**From:** Chris Pope [CPope@australand.com.au]  
**Sent:** Thursday, 16 June 2011 6:00 PM  
**To:** Georgie Kimlin; Matthew Allen; Lindsey Gray; Clare Swan; Kara Krason; Pierre Abrahamse; Costas Haramis; snaughton@syd.bonaccigroup.com  
**Subject:** FW: Variations to Wolli Creek Public Domain Plan

From: eroka@rockdale.nsw.gov.au [mailto:eroka@rockdale.nsw.gov.au]  
Sent: Thursday, 16 June 2011 4:58 PM  
To: Kara Krason; Chris Pope  
Cc: MAbra@rockdale.nsw.gov.au; MFasan@rockdale.nsw.gov.au; MSadek@rockdale.nsw.gov.au  
Subject: Variations to Wolli Creek Public Domain Plan

Please see feedback below on the proposed variations to the Wolli Creek Public Domain Plan.

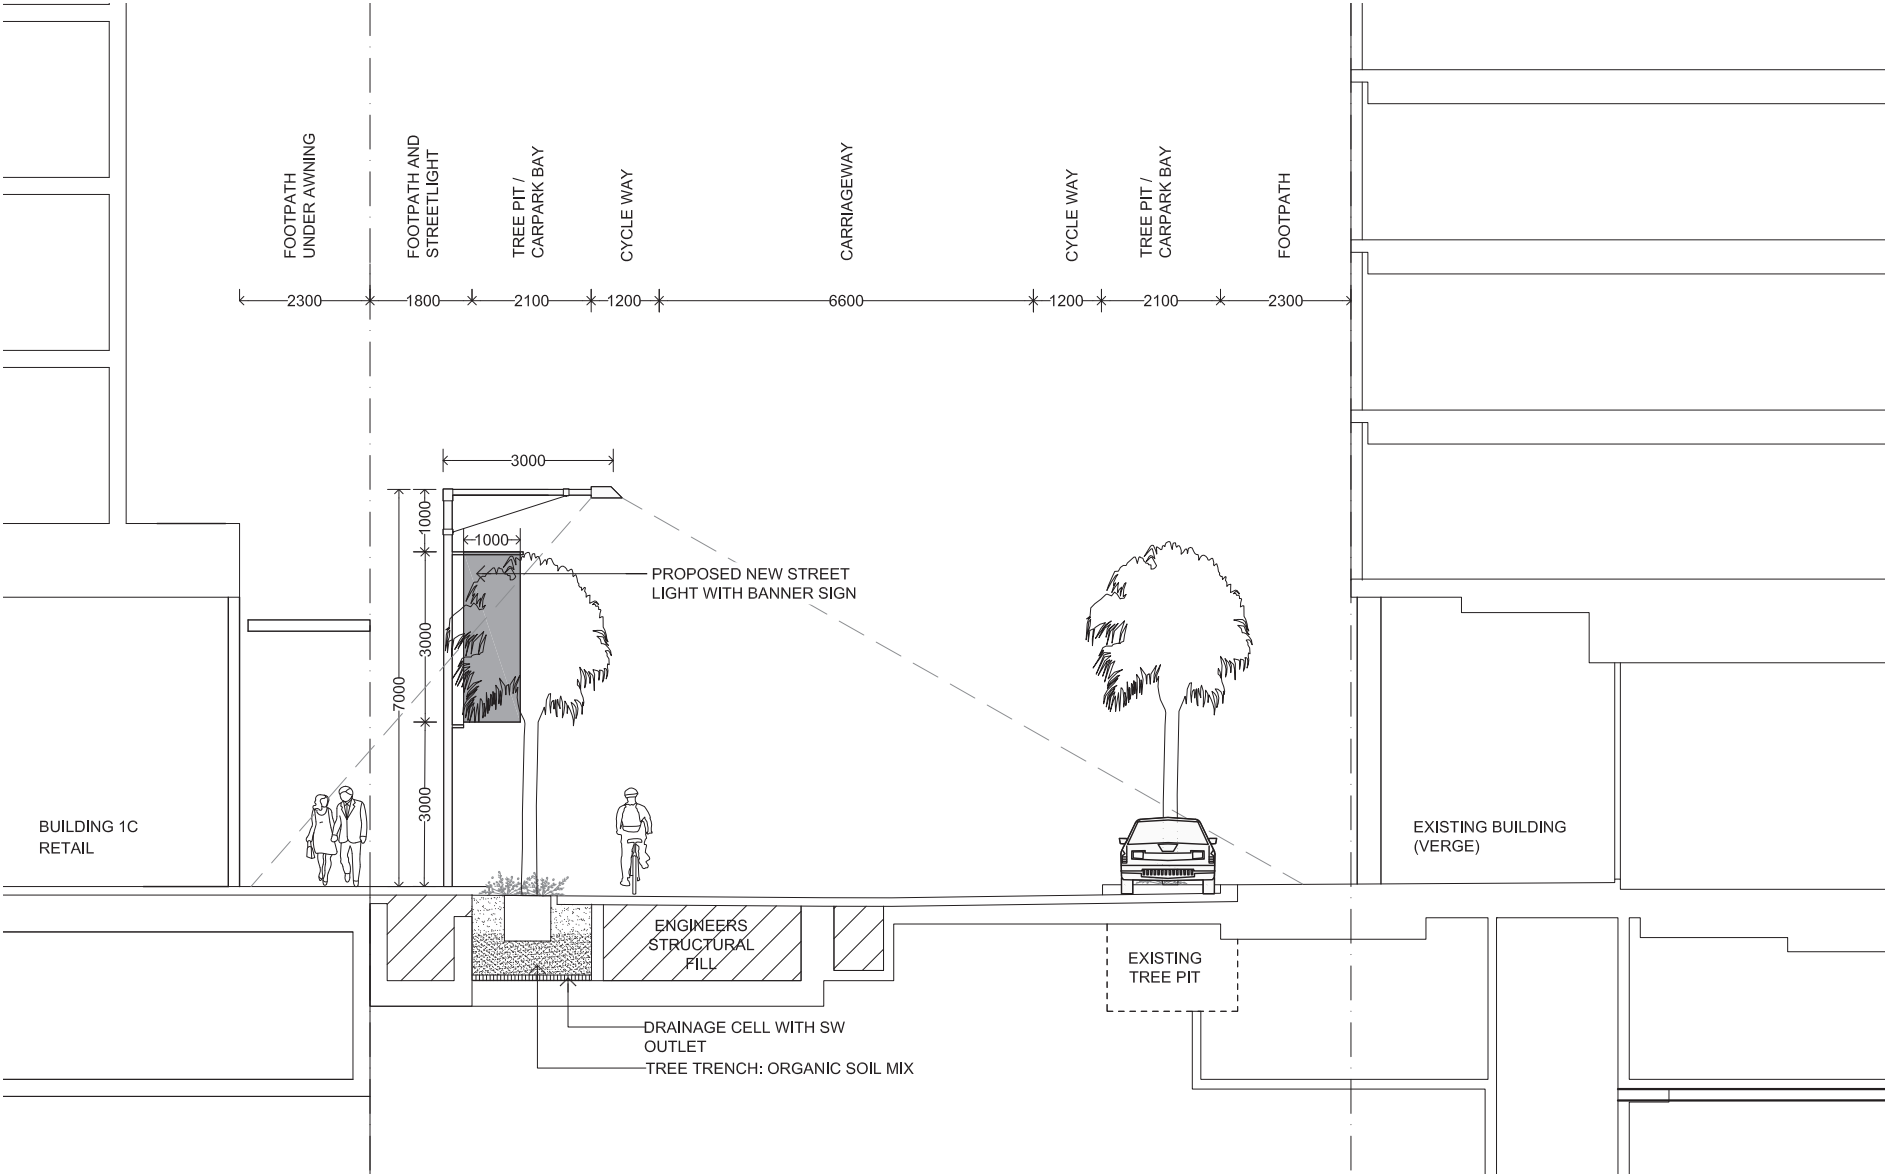
#### Drawing 02 - Brodie Spark Drive

The substitution of *Platanus digitala* (Plane Tree) specimens with *Livistona australis* (Cabbage Tree palms) is supported on the following proviso:

- all existing Plane trees along Brodie Spark Drive are removed and replaced with Cabbage Tree Palms. Palms to be installed with a minimum 4m clear trunk height
- an automatic irrigation system is installed to each planter
